**ARDEX Warehouse and Manufacturing Facility - Response to Submissions
- SSD-25725029 - 657-769 Mamre Road, Kemps Creek**

Thank you for providing Penrith City Council with the opportunity to comment on the Response to Submissions documents related to State Significant Development (SSD).

Figure 1: Site Plan

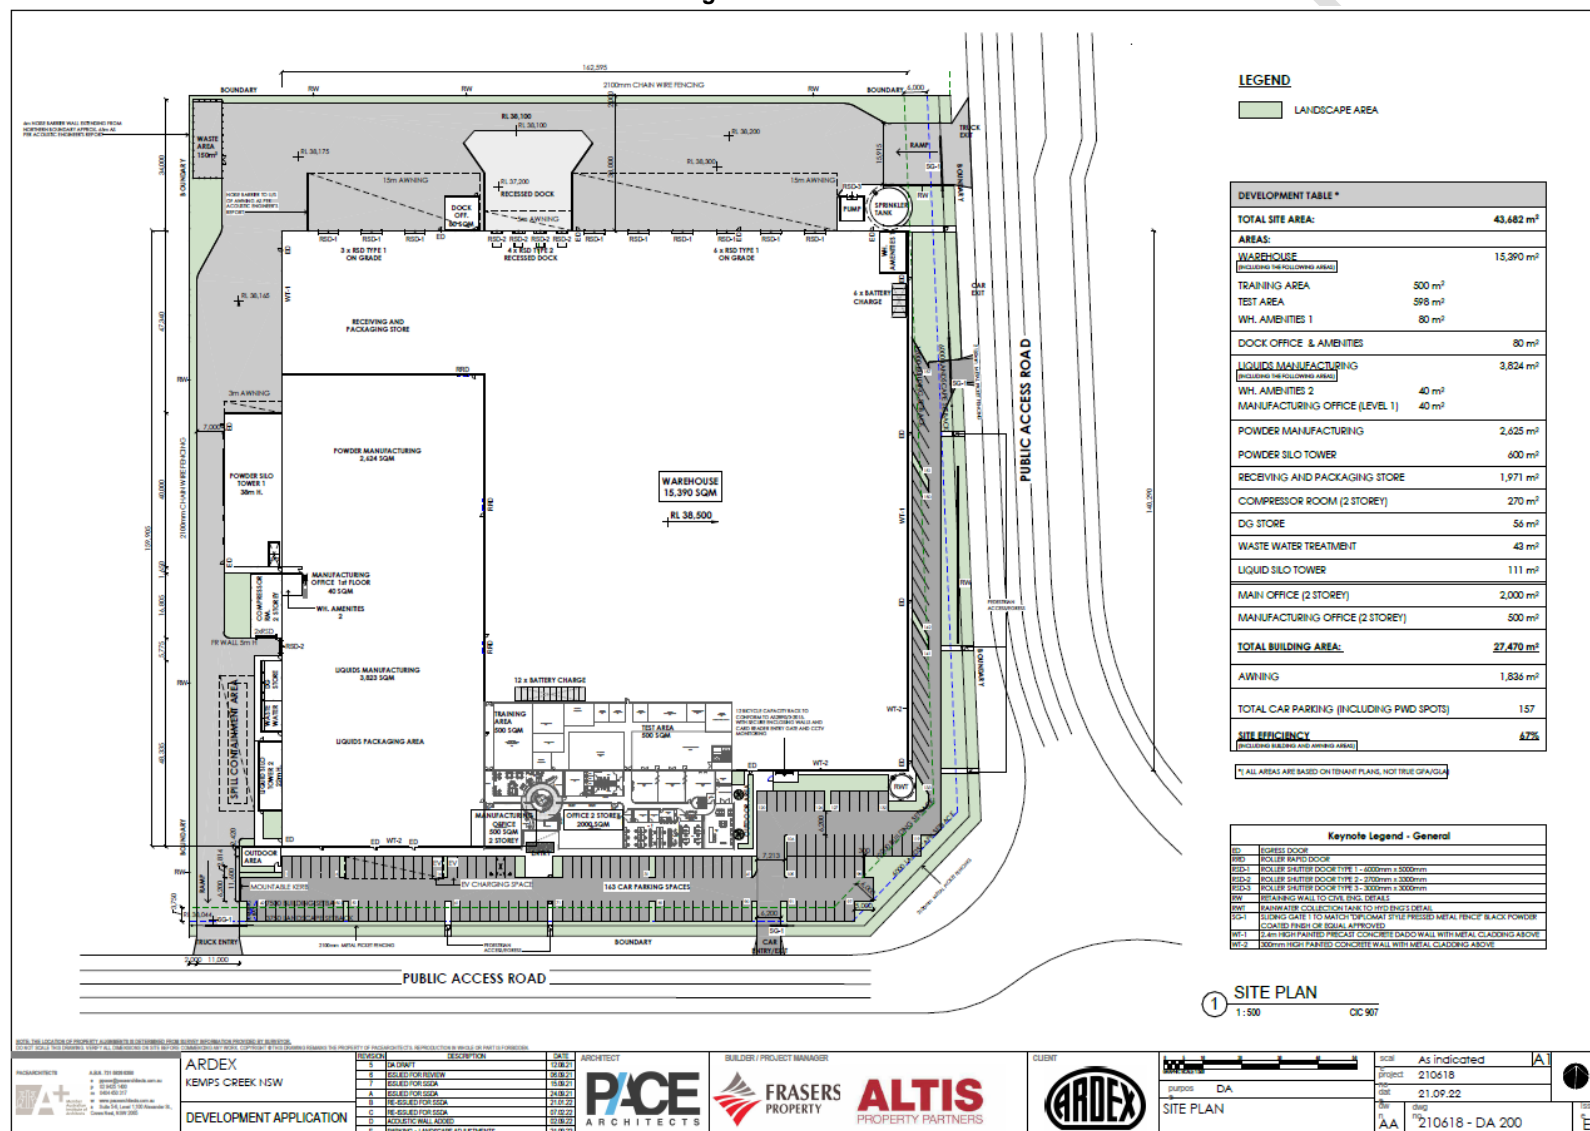
The building setback to the southern frontage does not comply with the MRP DCP as it contains car parking. The email from DPE states that a 3.75m setback can be provided, which is correct, although the requisite building setback must then not include car parking as per control at 4.2.2 *Building Setbacks*, (4) of MRP DCP.

All car parking spaces which encroach into the landscaped setback are to be deleted i.e., spaces 120 and 97, 98 and the related aisle turning head is to be reduced. Car space one is to be deleted to allow for deciduous canopy tree and/or shrub planting adjacent to the staff/visitor outdoor area (noting the southern orientation).

The first 5 car parking spaces which are located opposite the driveway marked '9' (eastern frontage), on the amended landscape plans are to be deleted, as these result in poor planting outcomes along the street frontage – noting the limited width of the setback at the area marked '2', on the amended landscape plans.
